**INDEPENDENT ADVISORY
PANEL FOR UNDERGROUND
MINING**

**DENDROBIUM COAL MINE
LONGWALL 19
SUBSIDENCE MANAGEMENT PLAN**

February 2021

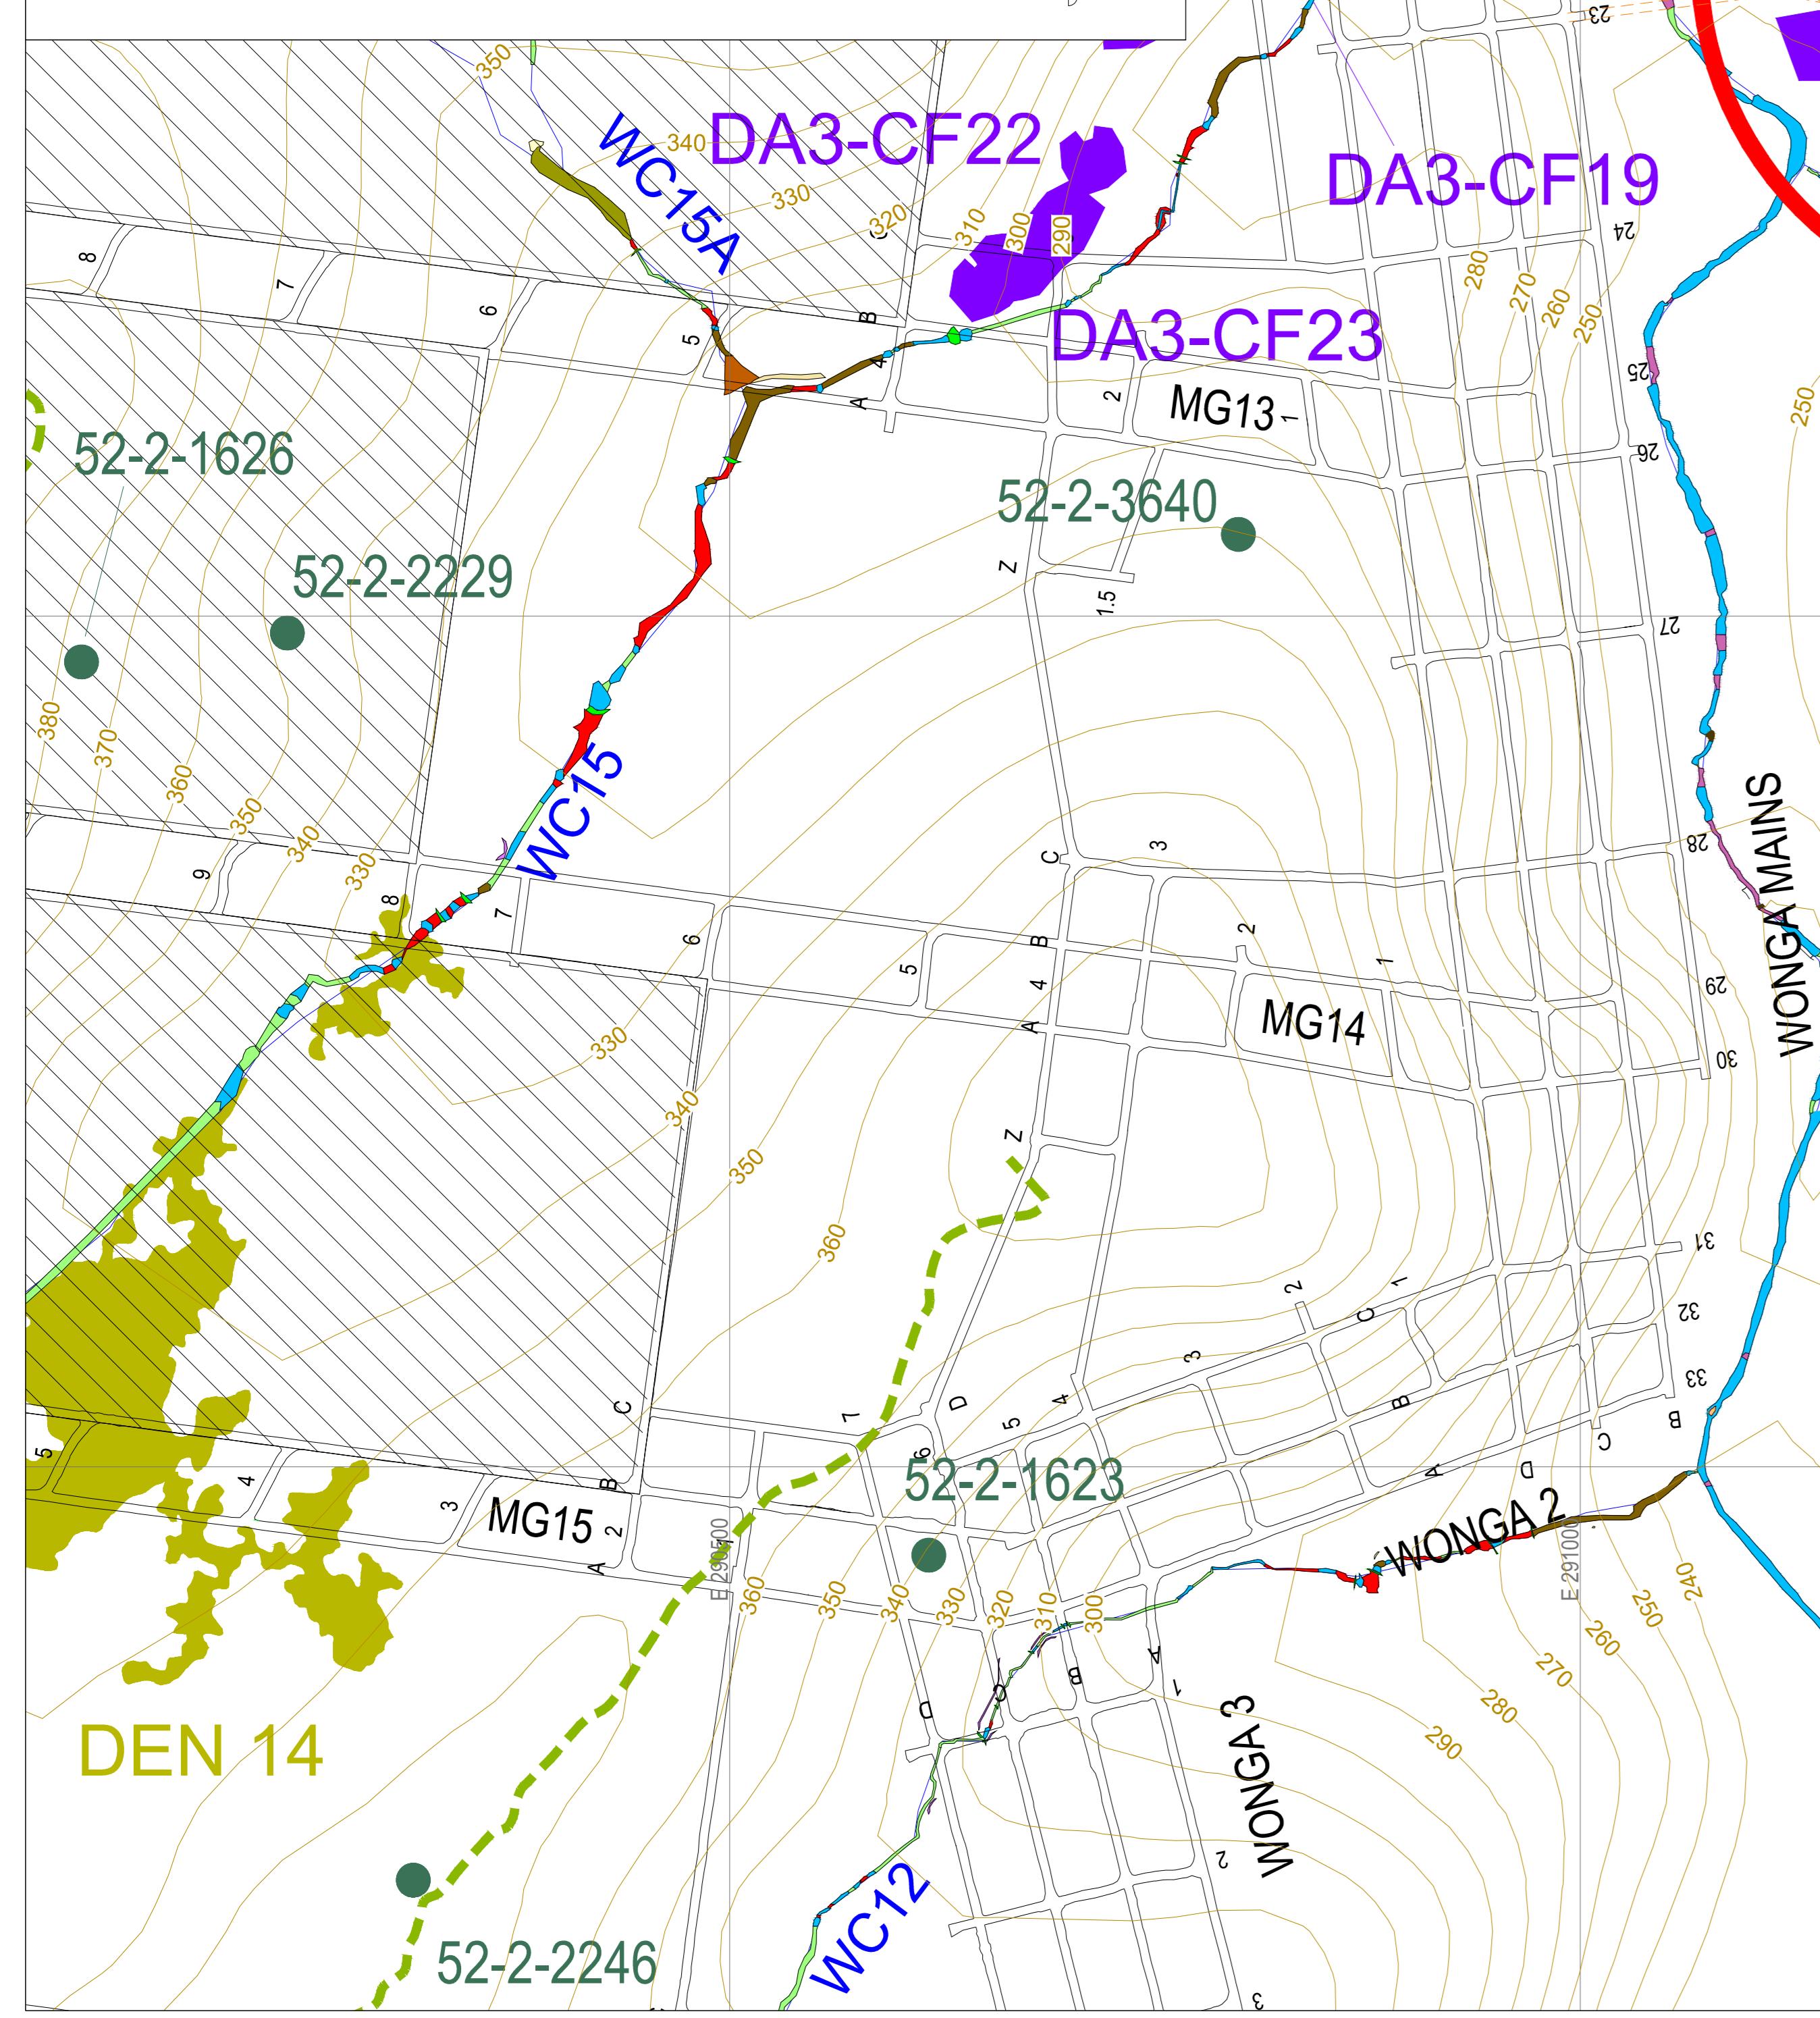
- The surface features map in Appendix 2 of Area 3A Watercourse Impact Monitoring, Management and Contingency Plan (South32, 2020b) shows near-continuous pools with intermittent riffles and one major rockbar opposite LW8. The predicted total valley closure of approximately 180 mm at this rockbar corresponds to a predicted 5 % rate of Type 3 impacts at this location, with 4% of that being accounted for by previous longwalls. The predicted rate of Type 3 impacts to the bedrock under the pools at the point of maximum valley closure is 7 %, with around 4 % of that accounted for by previous longwalls, if the rockbar model is assumed applicable to pools. There is also potential for Type 3 impacts at the numerous riffles.
